City of Albuquerque Stormwater Construction Site Inspection Report

ESC File No.	A11E017_Omni	Project Name:	Omni Universal Trust Lots 8 & 9 Unser/McMahon	
NPDES Id. No.	NMR1005E9	Location:	5762 McMahon Blvd NW	
3/13/2023	Owner			Contractor
Operator	Omni Universal Trust			Caldon Seeding & reclamation
Contact name & title	Michael G Rosenberg trustee			Len Horan
e-mail	mgr@lobo.net			lenhoran@rocketmail.com
Contact Phone #	970-259-7501			505-699-5913
COA Inspector	Doug Hughes	Start/End Time:	9am	
Construction Phase:	Lots 8 & 9 Graded with subdivision (CGP ID# NMR1004PN)			
Type of Inspection:	<input type="checkbox"/> Regular	<input type="checkbox"/> Storm Event	<input type="checkbox"/> Post Storm Event >0.25"	<input type="checkbox"/> 311/Complaint <input checked="" type="checkbox"/> Follow Up
Weather at time of inspection?	Clear		Temperature: ~	50
Estimated date of last storm 0.25" or greater	12/4/2022

ENGINEER'S SEAL	UNSER & McMAHON
		Unser Blvd & McMahon Blvd
		EROSION CONTROL PLAN
		SHEET #
		ECP-1
		JOB #
		2020015

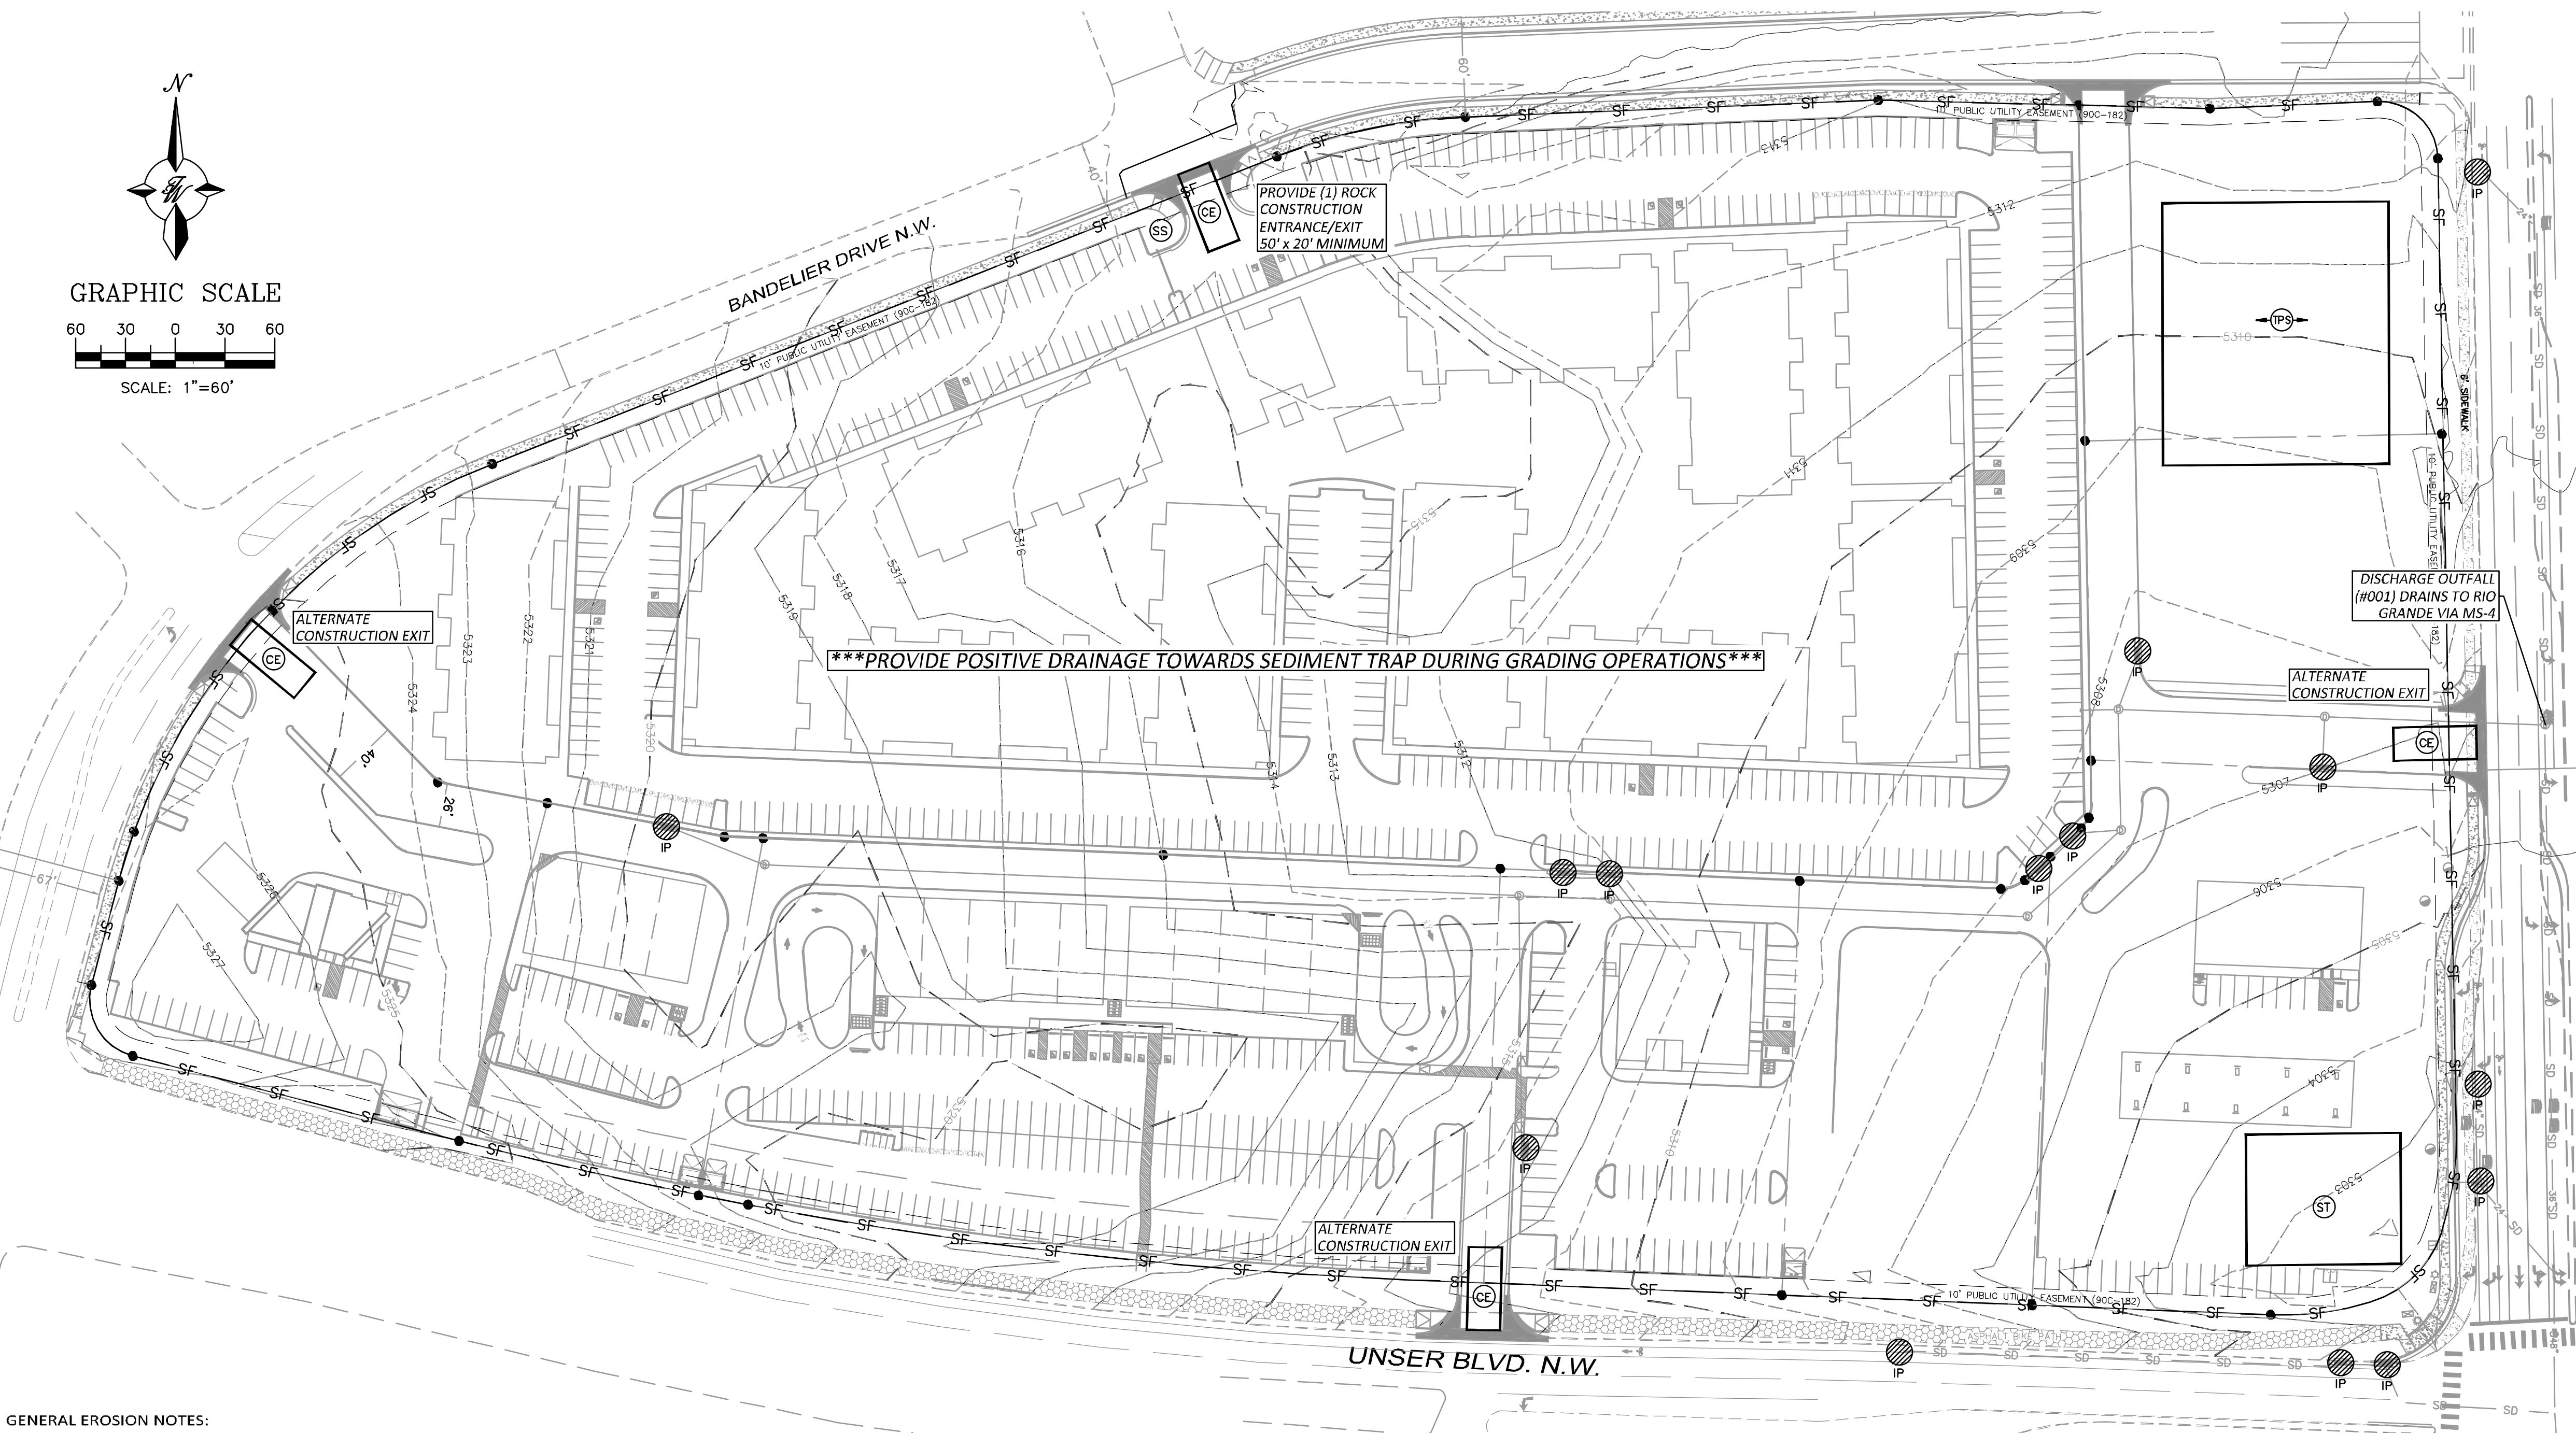
4	BMPs missing - Silt fence is full of sediment or has fallen down in most places along the north side. It is missing on the other three sides. Silt fence is required around the perimeter until the final stabilization criteria is satisfied.
	There is sediment next to the curb on the east and west sides of the site. Sediment must be removed from the adjacent streets and sidewalk.

SWPPP INFORMATION SIGN (SS)

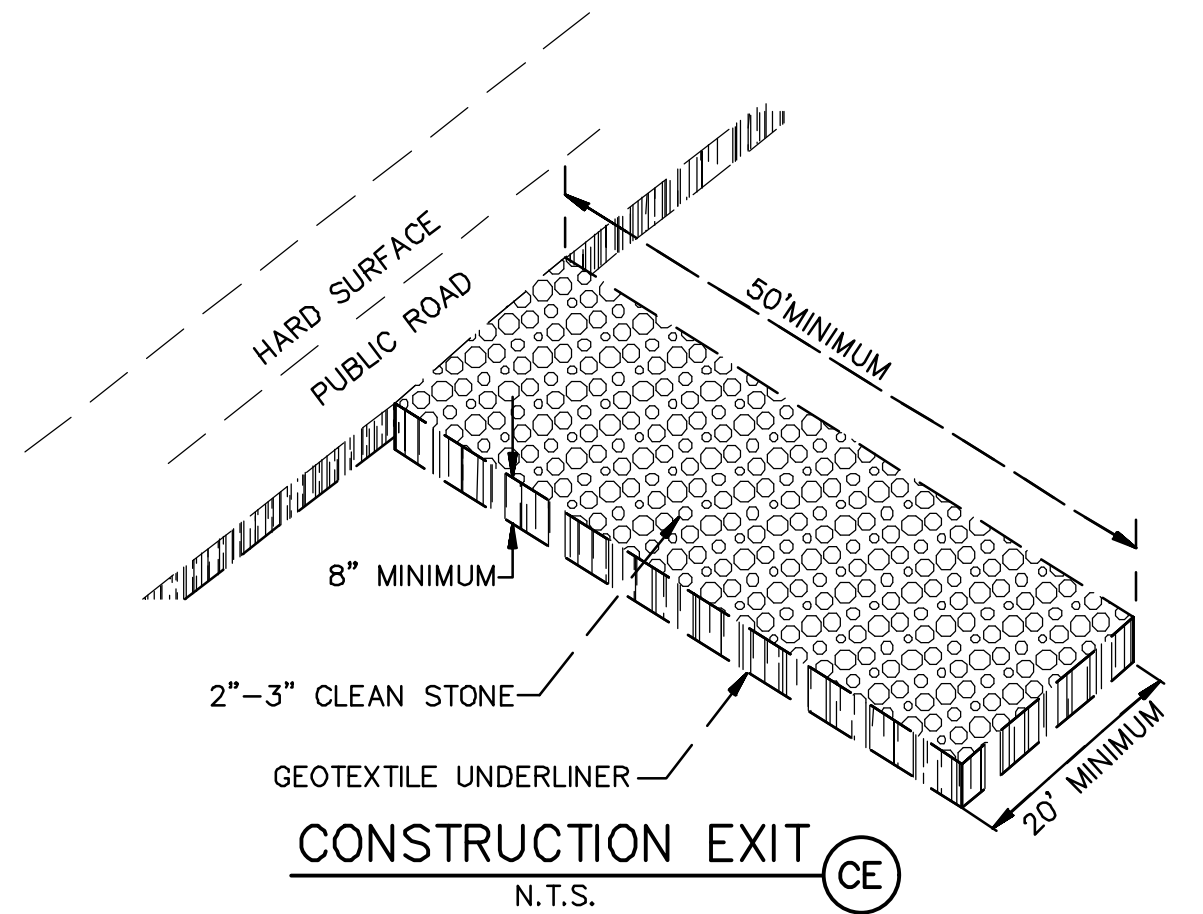
Item Number	Deficiency/ Corrective Action
1	Permit coverage wasn't posted. You must post a sign or other notice of your permit coverage at a safe, publicly accessible location in close proximity to the construction site. The notice must be located so it is visible from the public road that is nearest to the active part of the construction site, and it must use a font large enough to be readily viewed from a public right-of- way per CGP 1.5
2	SWPPP wasn't available on site at time of inspection, so it couldn't be checked to see if it is up-to-date. - Provide a scanned copy of the up-to-date SWPPP with all reports to the Storm Water Quality Section at 600 2nd St NW suite 400 - Jhughes@cabq.gov - Per CGP 4.8.2
3	Stabilization was missing - You must continue permit coverage, self-inspections, SWPPP and BMP maintenance until the City determines that the Final Stabilization Criteria CGP2.2.14.c has been satisfied. Then you must remove the BMPs and send documentation of the Final Stabilization to the EPA with a Notice of Termination (NOT) per CGP 8.2 to end your coverage under the CGP. This step is independent of the Work Order. Please copy me with the documentation and the EPA's acceptance of the NOT at that time. In the meantime seed and Hydromulch are required per CGP 2.2.14.
